218948

Appendix A – Response to Submissions

Extracts from Government agency and authority submissions and submissions from the general public received in relation to SSD 10342, and a response to each of these matters, has been provided in the sections below.

Drawing Status  
**Issue**

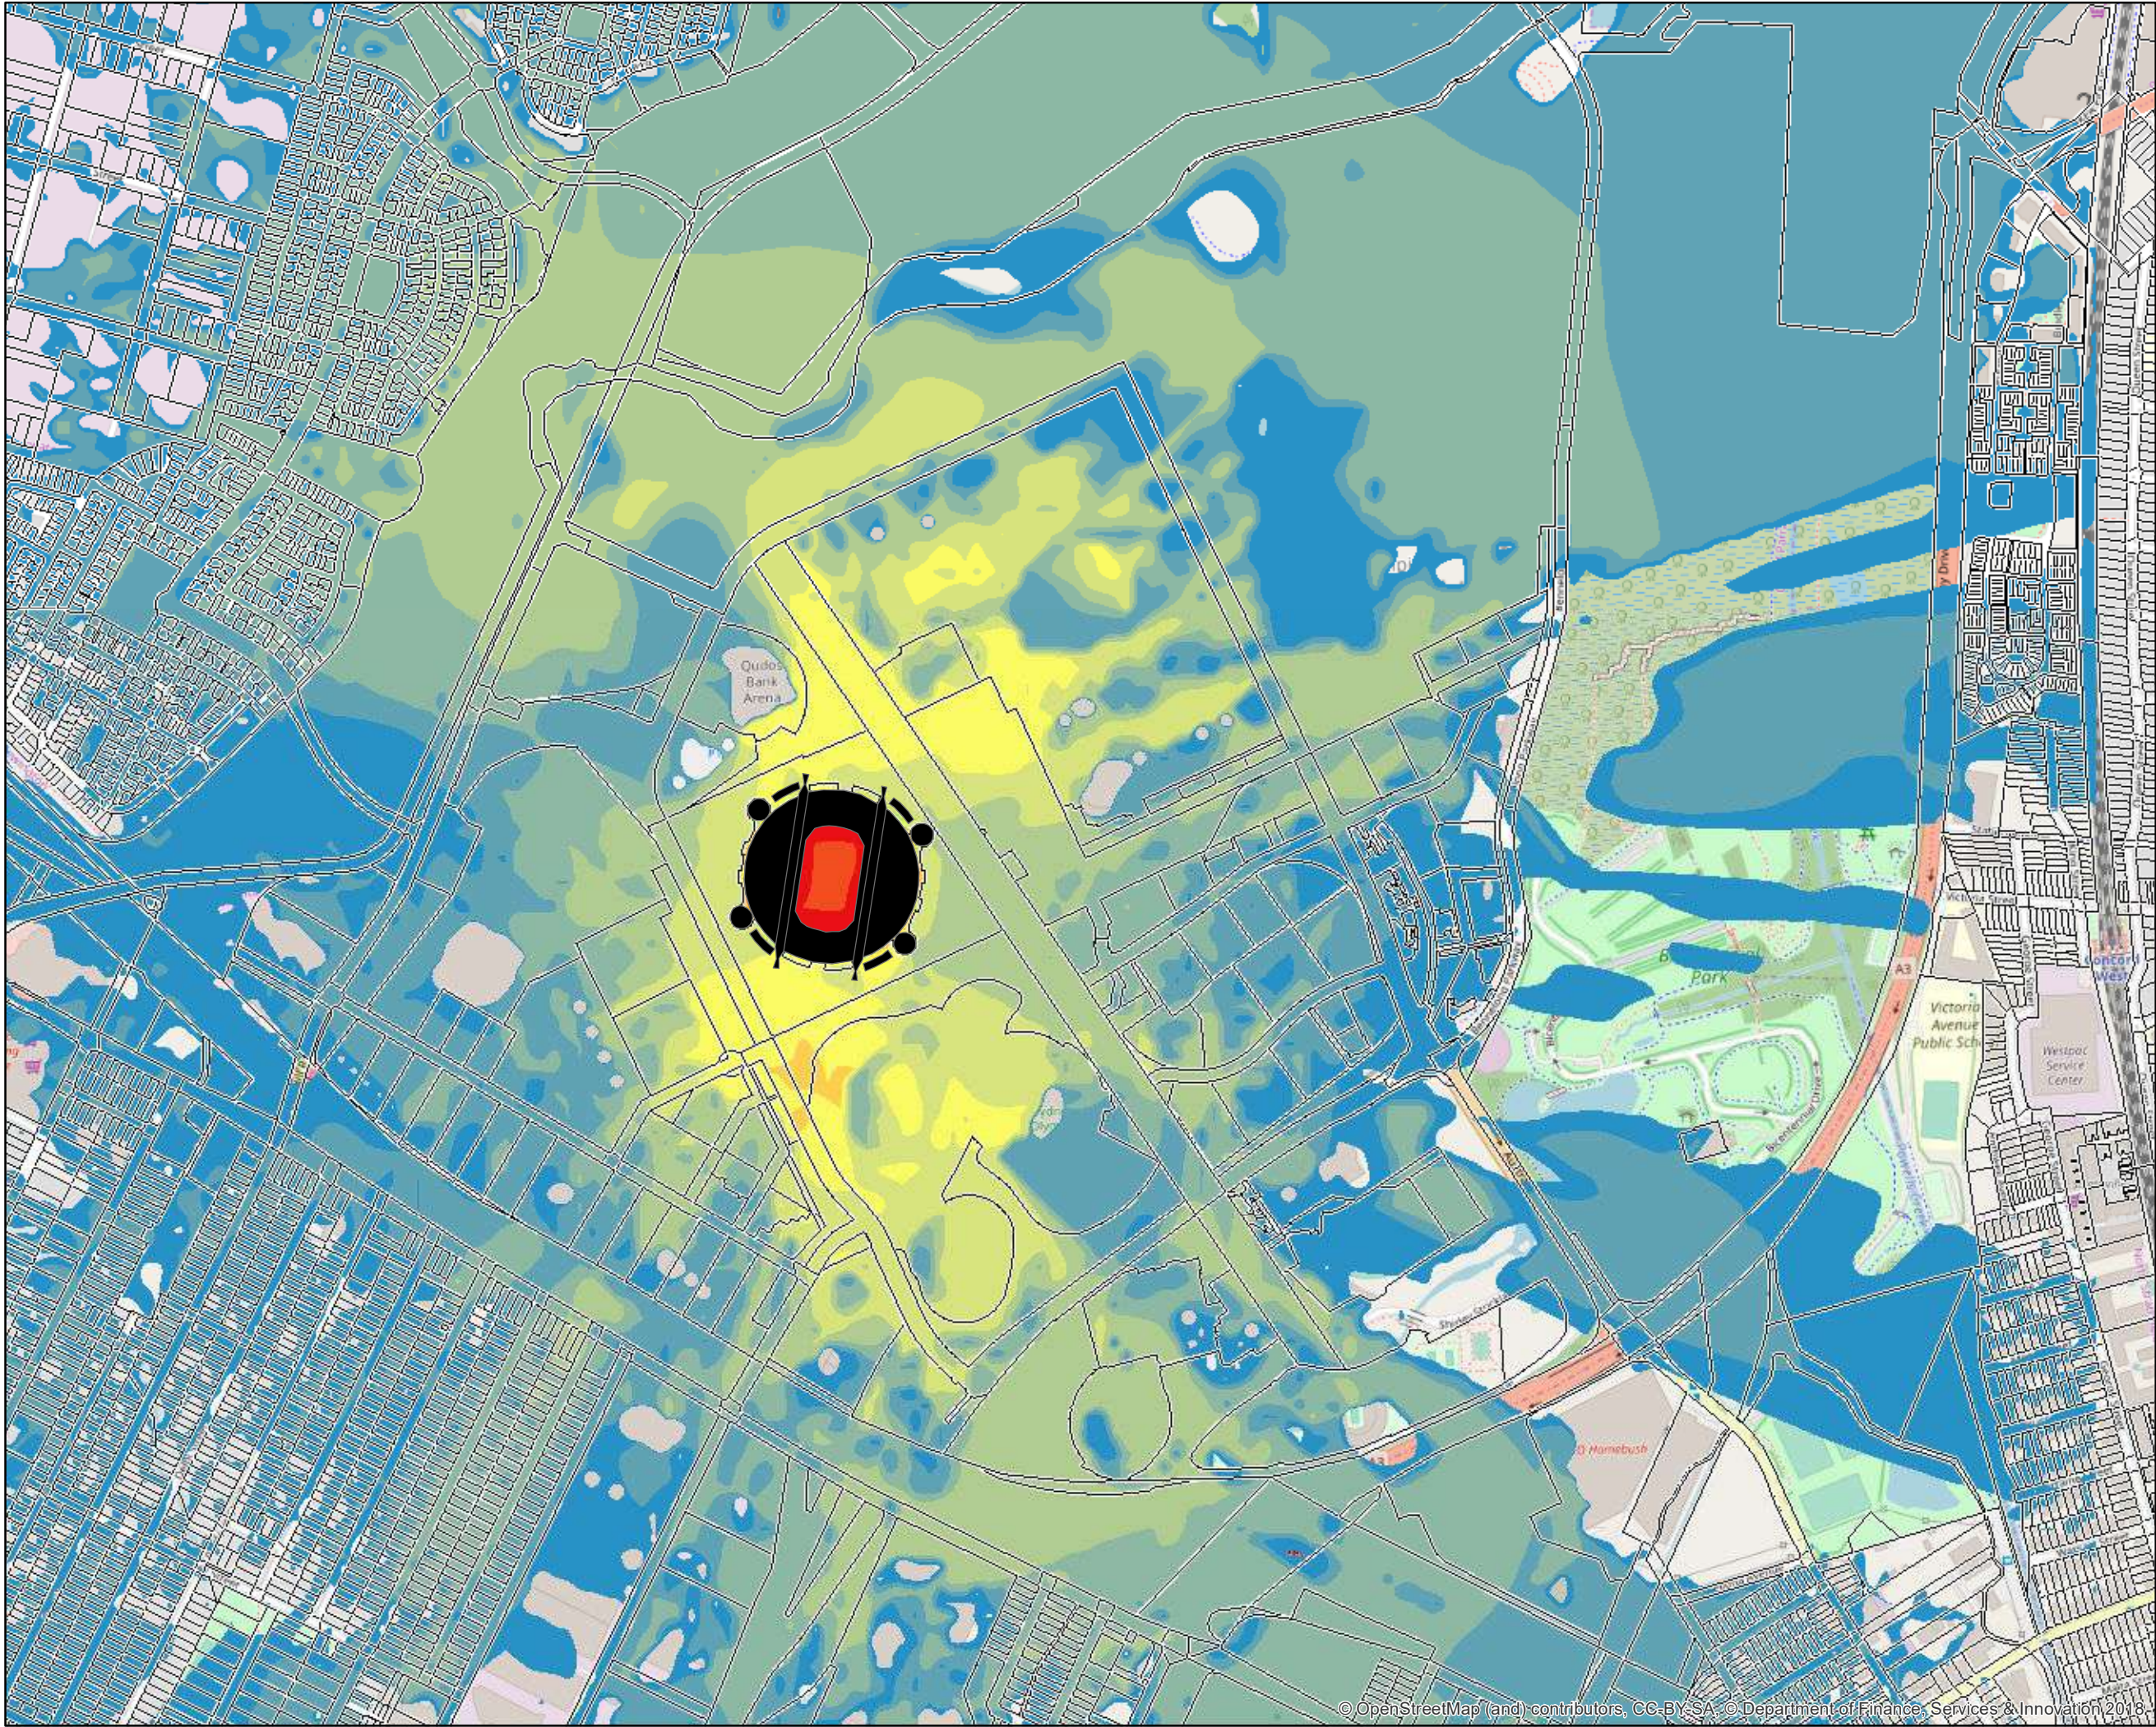
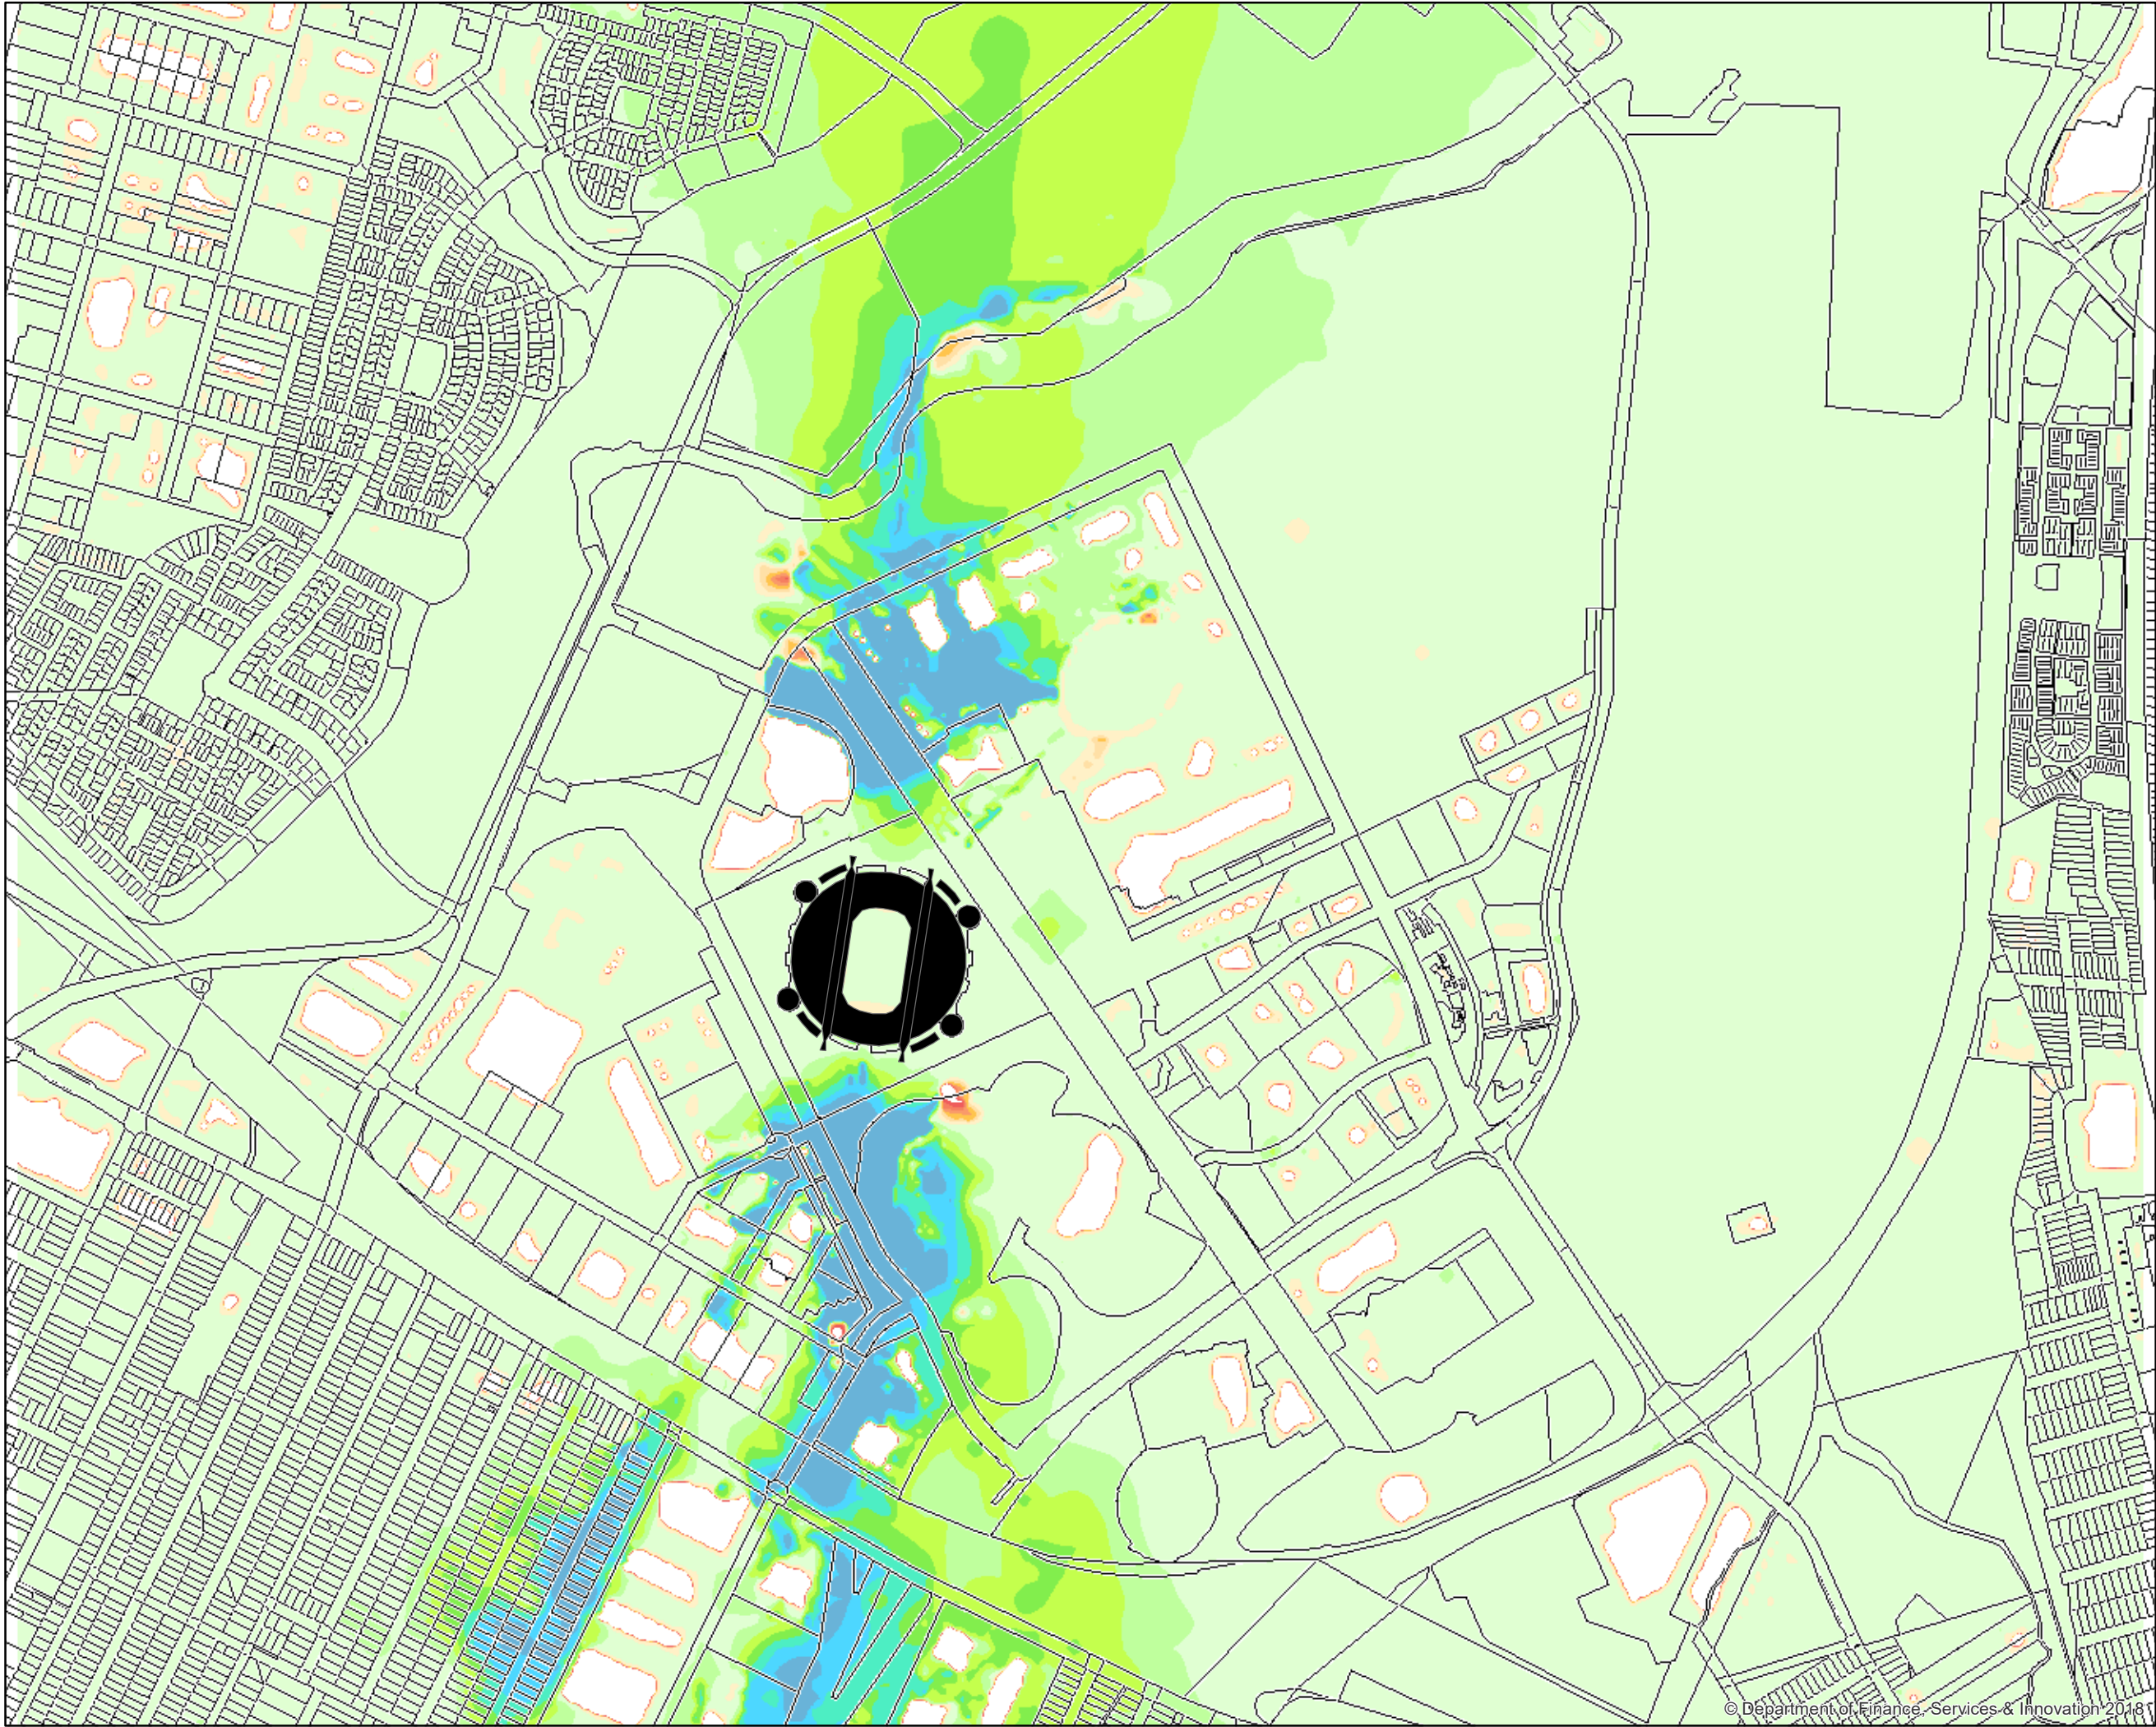
No.	Extract	Comment
EPA6	<p>Event noise management</p> <p>a) The Sydney Olympic Park Authority Act 2001 establishes the Sydney Olympic Park Authority (SOPA) as the Appropriate Regulatory Authority (ARA) for the stadium. The Act also includes a noise limit for events as the maximum permissible noise level from event noise of $L_{10,15min}$ 85 dB(A) at the nearest residential façade. The Noise Report has only presented a change in noise level in $L_{eq,15min}$. The EPA notes that the proposed modifications are generally minor in nature with regard to noise emissions. The Noise Report presents a comparative noise assessment for operational noise from events at the stadium. The predicted difference in noise levels presented in the report is relatively minor. The assessment does not present predicted noise as an absolute noise level and therefore the noise level potentially experienced by receivers adjacent to the stadium is not included in the report. This means that the footprint of noise impacts is not defined in the report and, as a result, an analysis of measures which could be implemented to reduce the noise footprint of the stadium is not able to be undertaken.</p>	<p>Section 4 of the revised Noise and Vibration Impact Assessment at Appendix C of this Response to Submissions assesses the proposal against the SOPA Act 2001 noise limits. Receivers which existed at the time the Act was implemented have been assessed to $L_{10,15min}$ 85 dB(A) at the nearest residential façade. Results for both concert and sporting events have been assessed, with three typical concert stage configurations modelled. Predicted levels at receivers which have been constructed since the Act was brought in have also been presented for reference, and noise contours generated in Appendix E.</p> <p>Results show noise levels from both the existing ANZ Stadium and the proposed Stadium Australia comply with SOPA Act 2001 noise limits.</p> <p>The footprints of event noise impacts are also presented in event noise contours that are included at Appendix C.</p>
